Ref:
SSD-8114-Mod-6

RE: OBJECTION TO SSD-8114-Mod-6, Lindfield Learning Village – Out of School Hours Care facility, 100 Eton Road, Lindfield

Ku-ring-gai Council's objection to SSD-8114-Mod-6, Lindfield Learning Village – Out of School Hours Care facility, 100 Eton Road, Lindfield

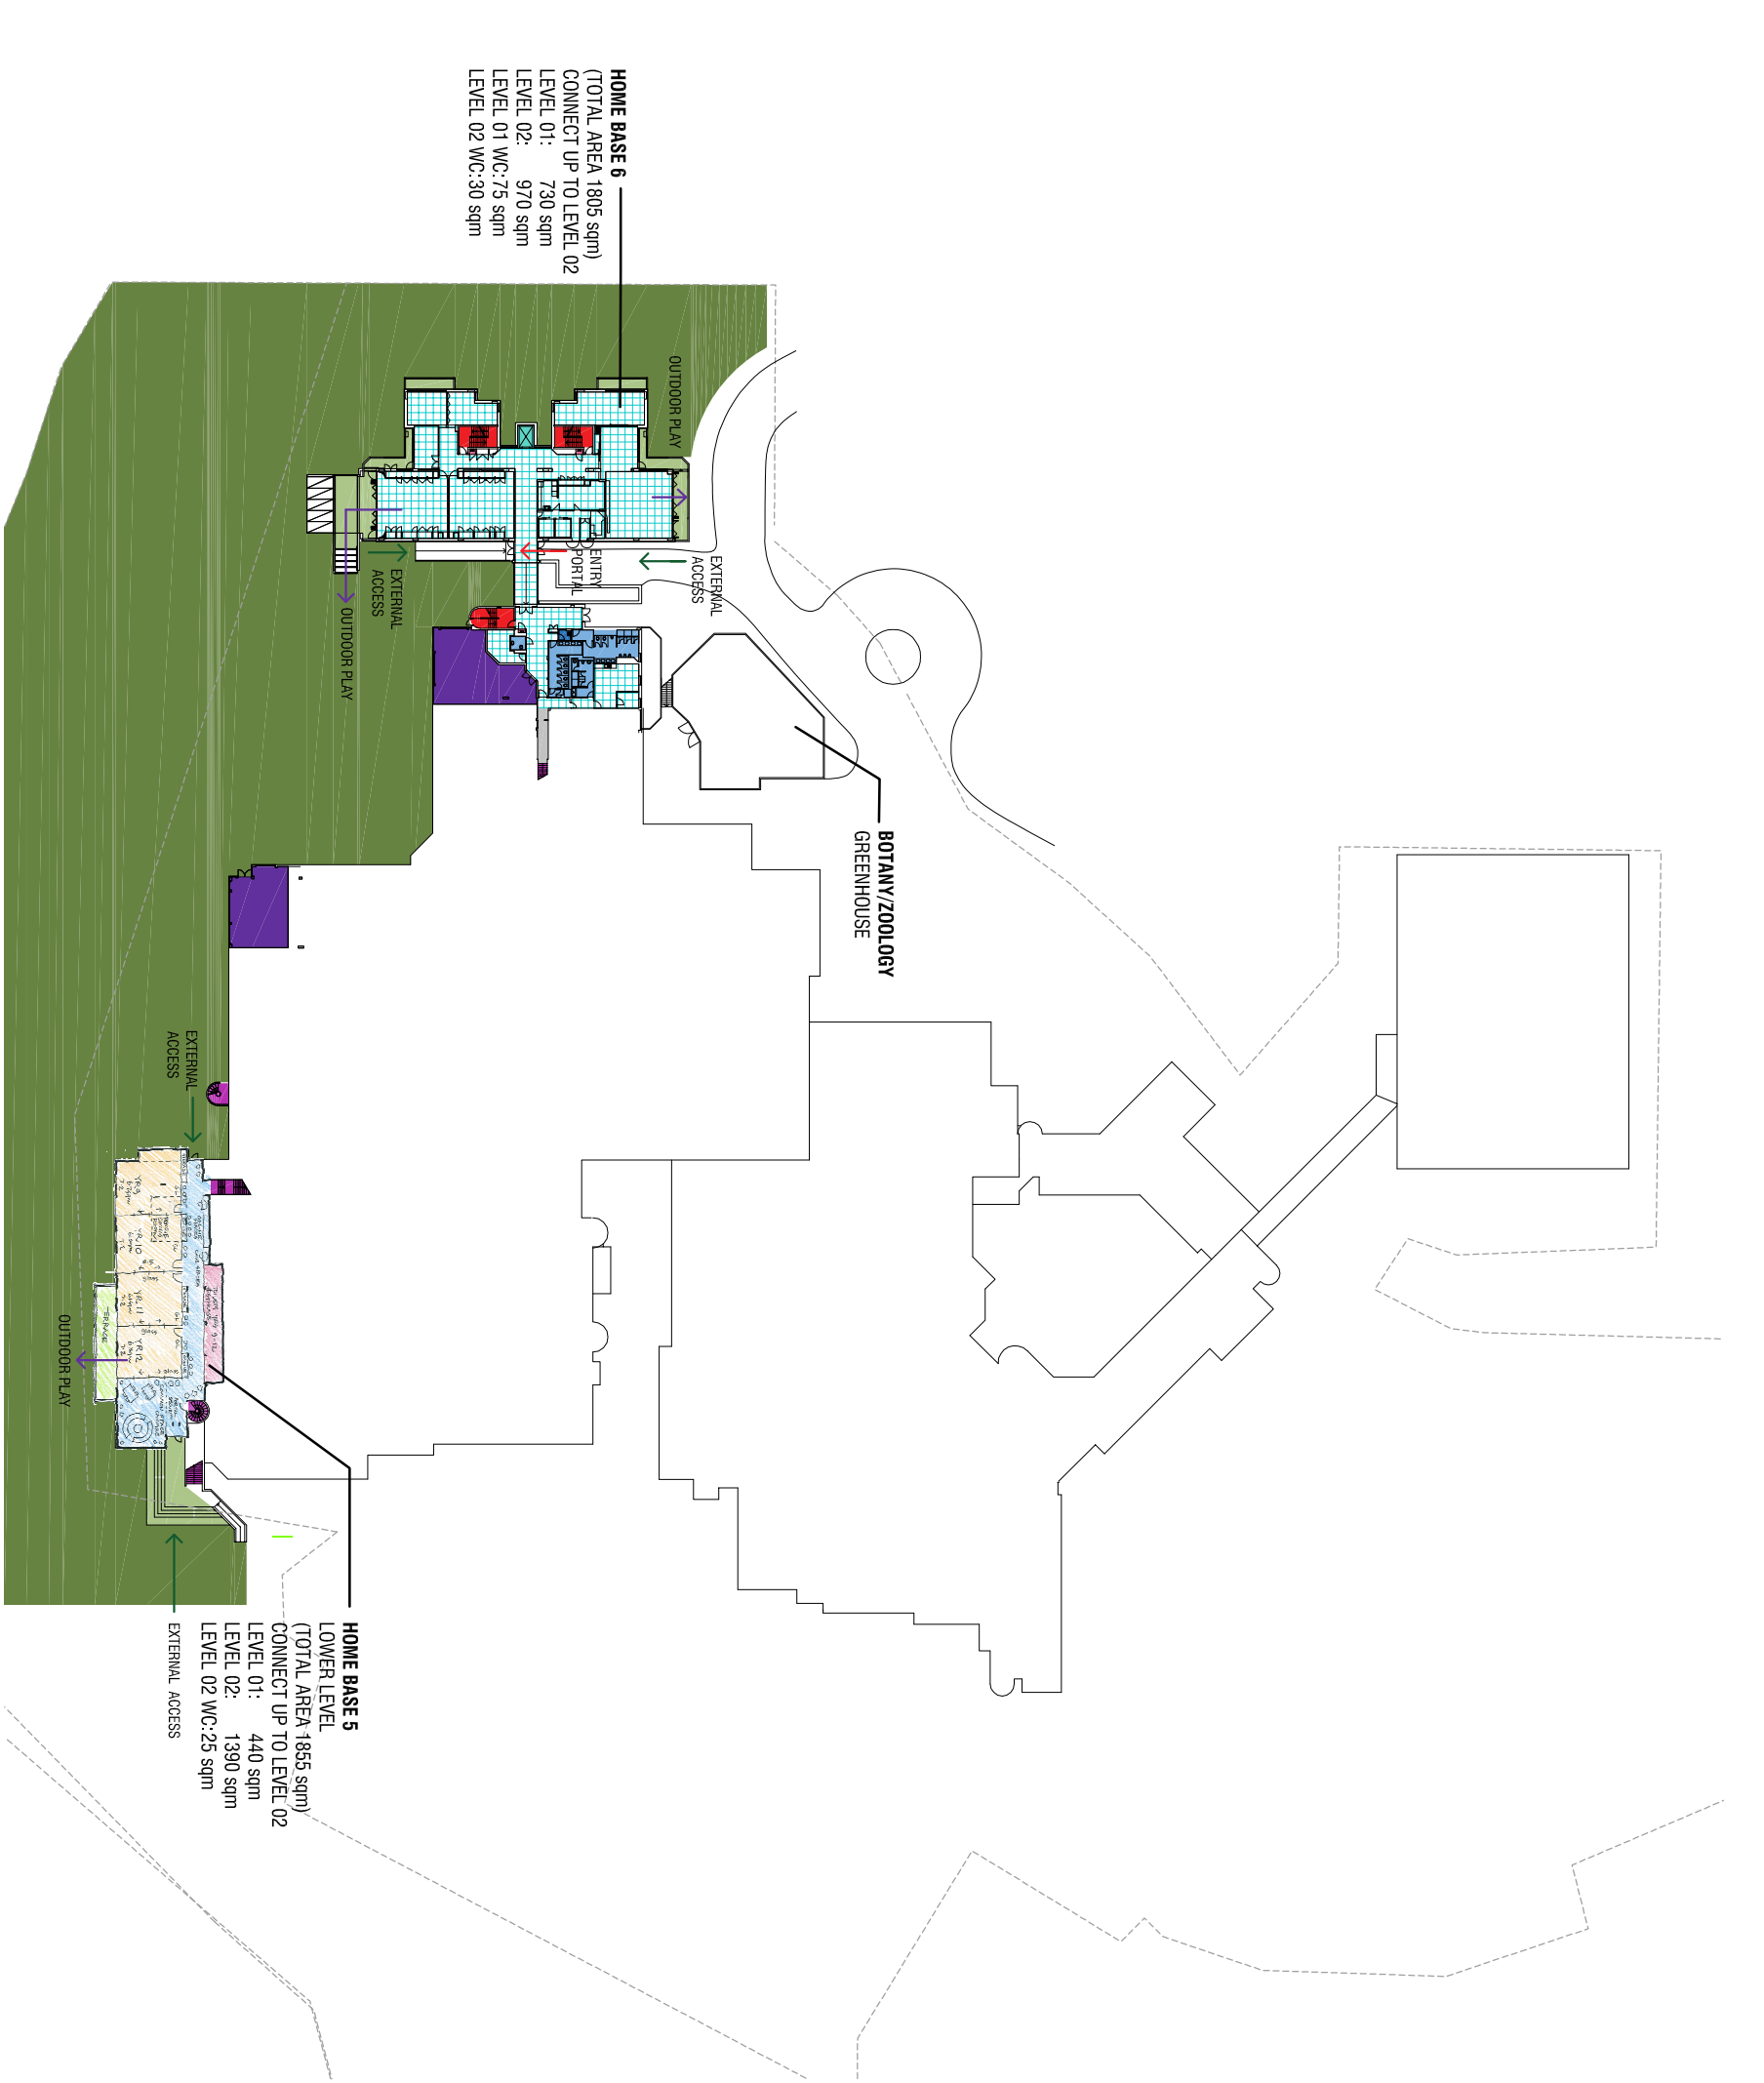
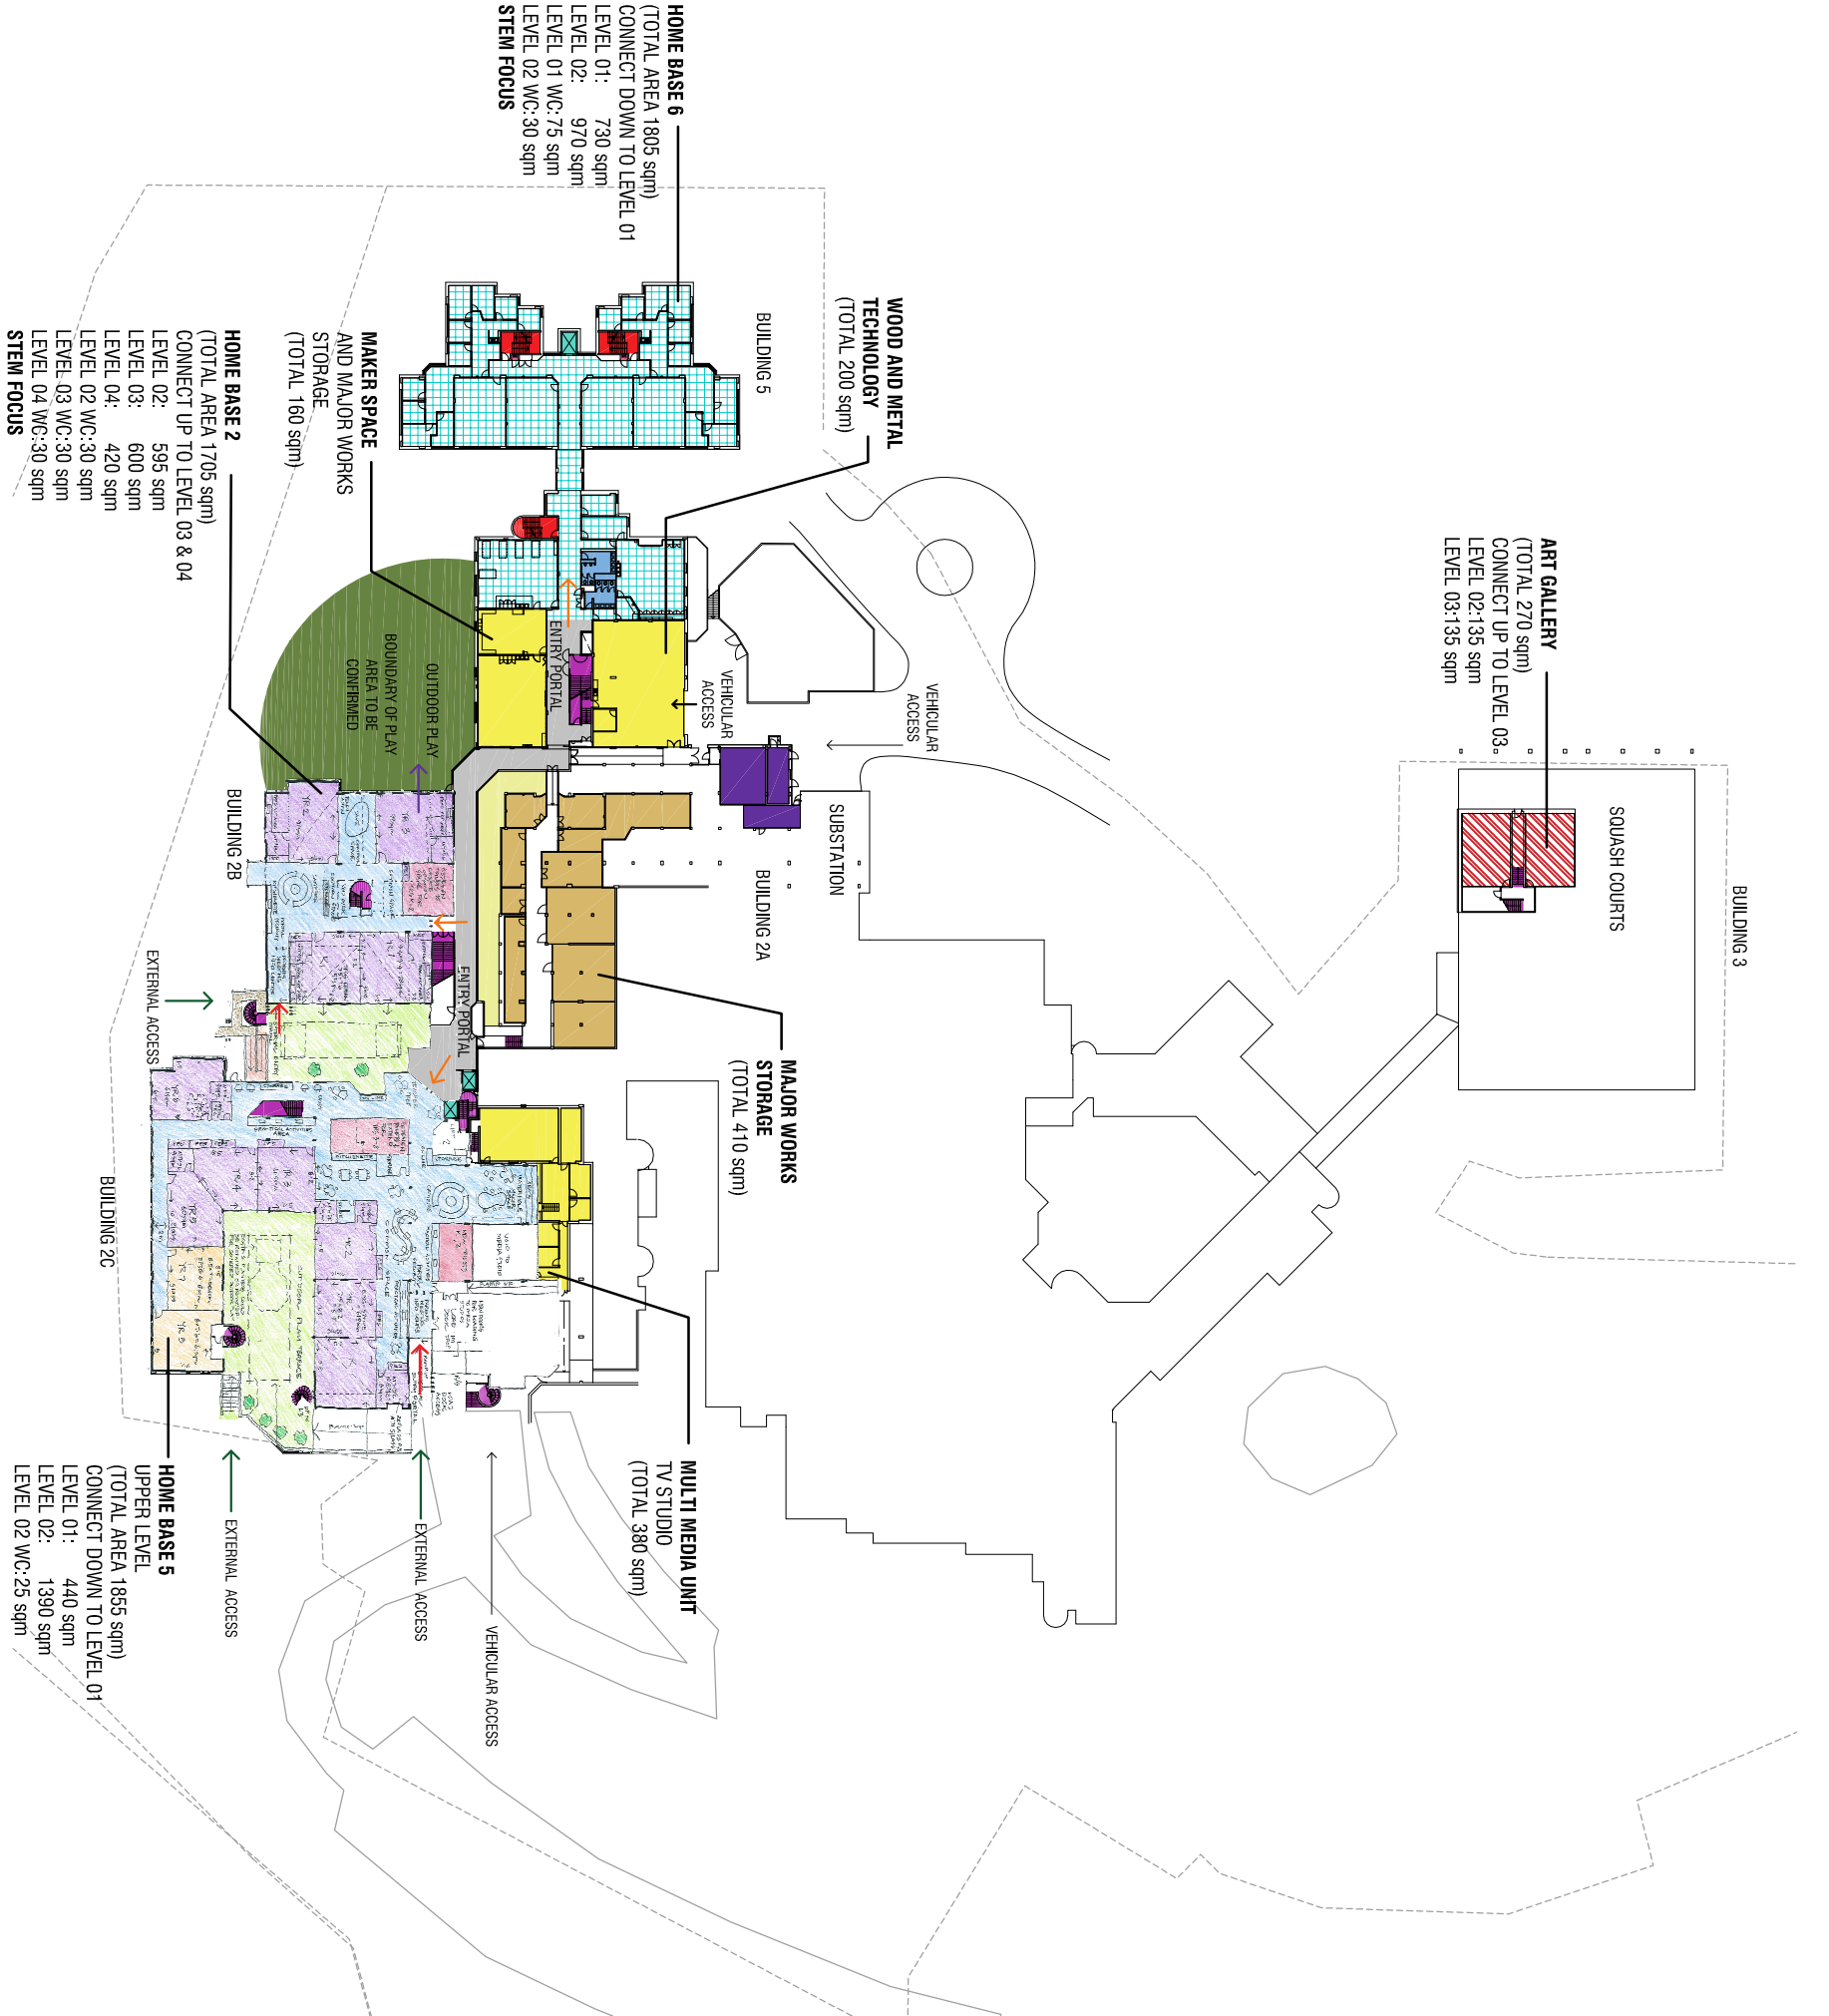
- The plans detail 'new works' that appear to fall outside of the scope of the modification application and are not clouded as 'new works'. As such, it is unclear whether these works are proposed, such as:

- The existing café is proposed to be relabeled as a staff kitchen however the plans do not appear to reflect this change and reference '*new extension to cafeteria / dining*'.

- The Applicant refers to fencing upgrades. The area clouded on the plan relates to security upgrades, however the plans also reference proposed new 2.1m and 1.3m high black tubular fencing, which is not clouded. Dimensioned elevations have also not been provided.

- The performing arts area is clouded, however there are no details of the proposed works in relation to this part of the site.
- A portion of the OSHC playground use is located on land zoned C3 Environmental Management. School based childcare is prohibited development within this zone. The Applicant has stated in the modification report:

- The submitted plans do not appear to be consistent with the scale bar. The correct scale should be provided to confirm that the proposal is compliant with the requirements of Clauses 107 and 108 of the Education and Care Services National Regulations including floor space ratio and indoor and outdoor play space.
- The modification application report has not considered the requirements of the Education and Care Services National regulations.
- All proposed works/uses should be clearly annotated and clouded.
- The site is a listed heritage item. If physical works are proposed, a heritage impact statement should be provided.
- An access report has not been provided and is necessary to undertake an assessment to ensure accessibility.
